Subject: Burroway Solar Farm (SSD-55968733) – Environmental Impact Statement

Attachment A

Detailed advice to DPHI Planning & Assessment regarding the Burroway Solar Farm (SSD-55968733) – Environmental Impact Statement

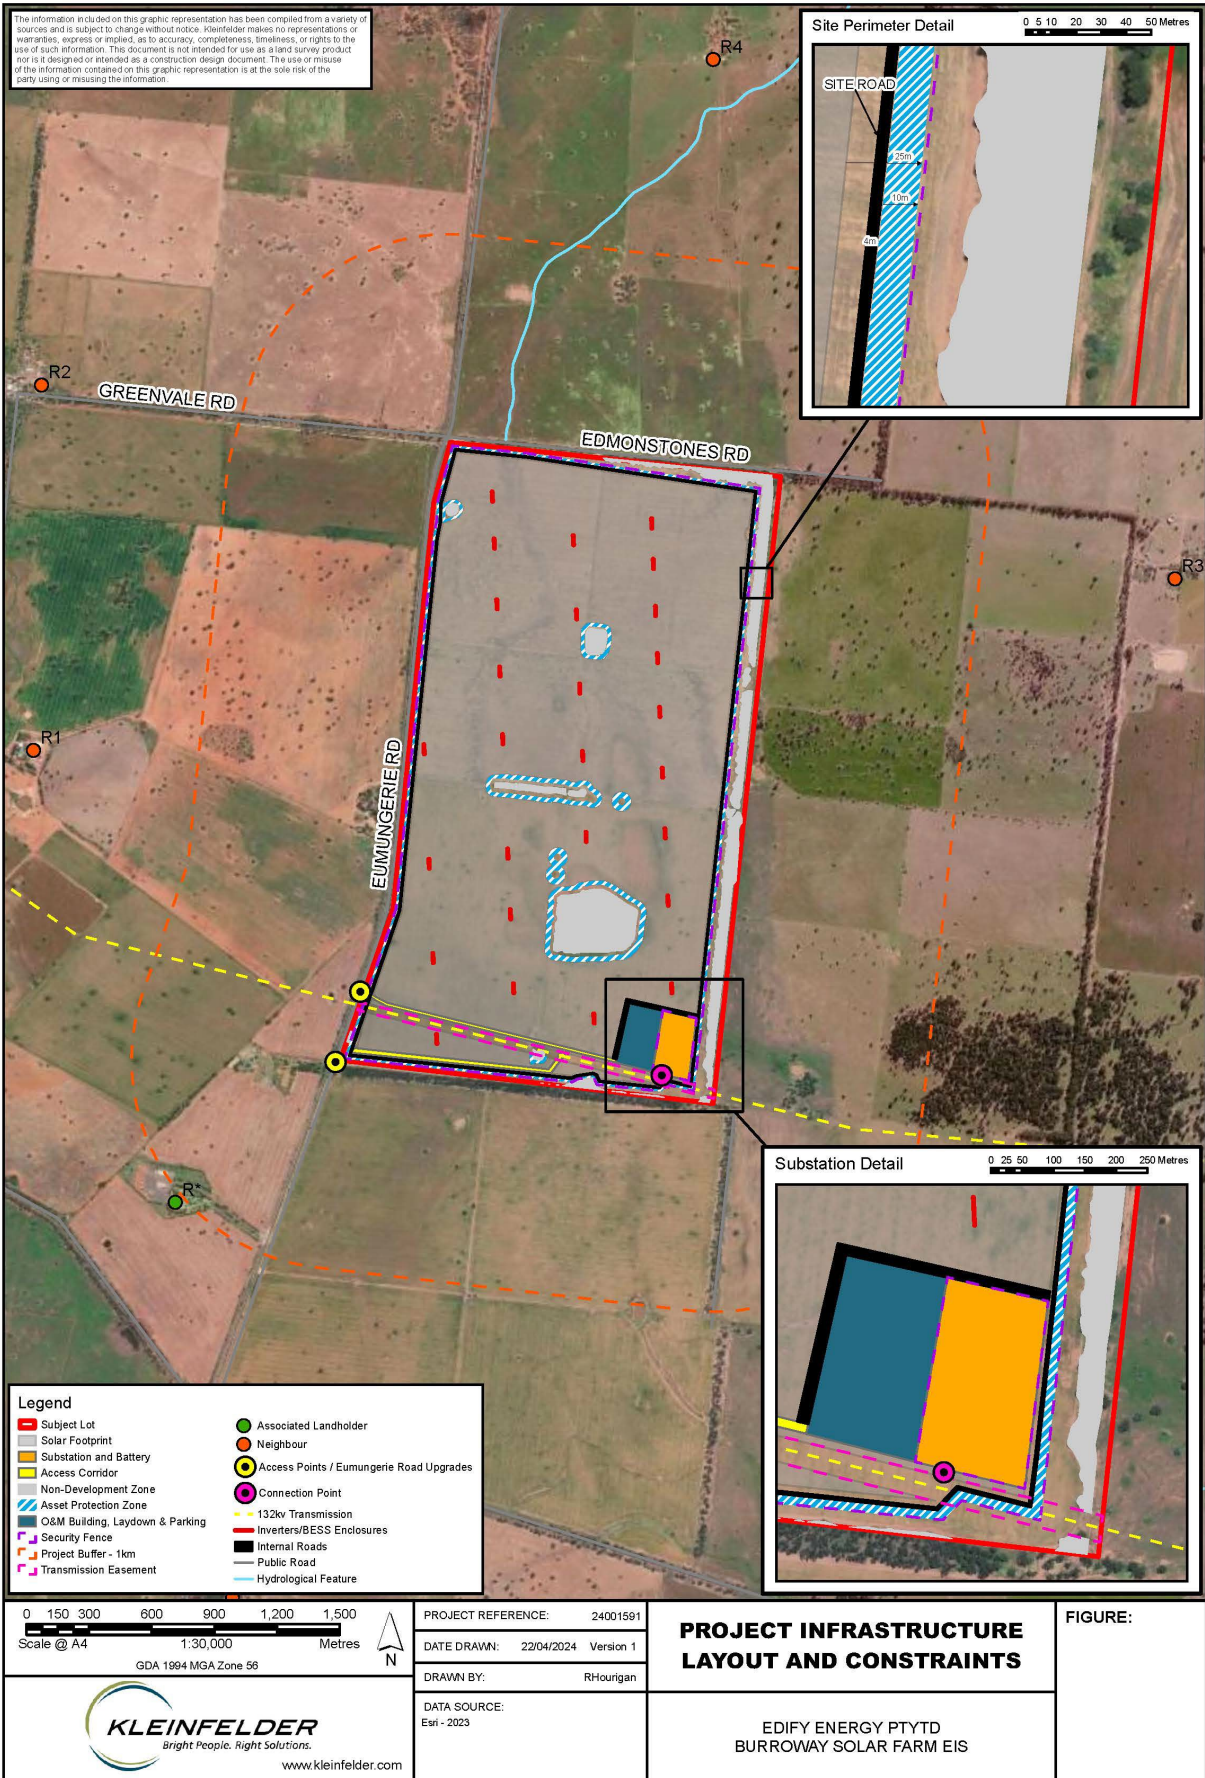
The proponent should confirm the licensing arrangements for any dams on site.

The project infrastructure layout identifies several dams which are within a “non-development zone” suggesting these are to be retained, but other sections of the EIS mention that some dams will be removed. Confirmation on which dams are to be retained or removed and details of the proposed licensing arrangements is requested. The proponent should consider relevant exemptions or exclusions under the Water Management (General) Regulation 2000, harvestable rights or entitlement requirements.
